## PLANNING AND COMMUNITY DEVELOPMENT

**RESPONSE TO COMMENTS: March 23, 2018**

Subject: SF184 Meadow Brook Crossing Filing No. 2- Review 1

MEADOWBROOK CROSSING FILING NO. 2

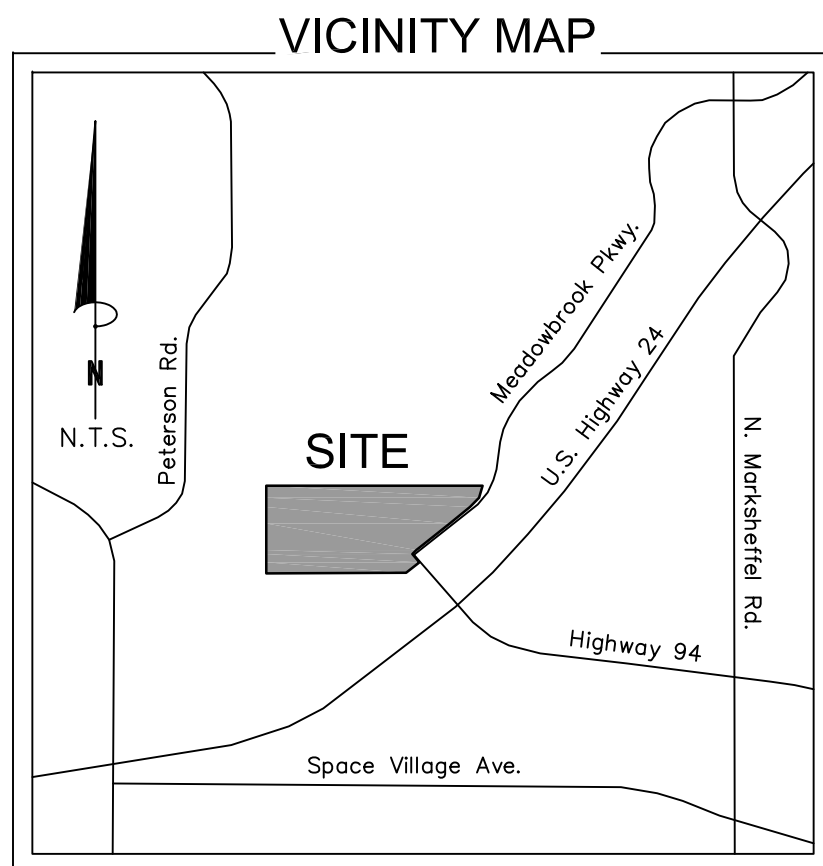
1. See Letter of Intent and Plat red lines  
**RESPONSE: LOI and Plat items revised per the redlines.**
2. Please fill in the avigation easement note on the plat. An Avigation Easement was recorded for this property on March 17, 2017 (Reception No. 217030936); also provide the notice and disclosure statement.  
**RESPONSE: Avigation easement note updated as requested.**
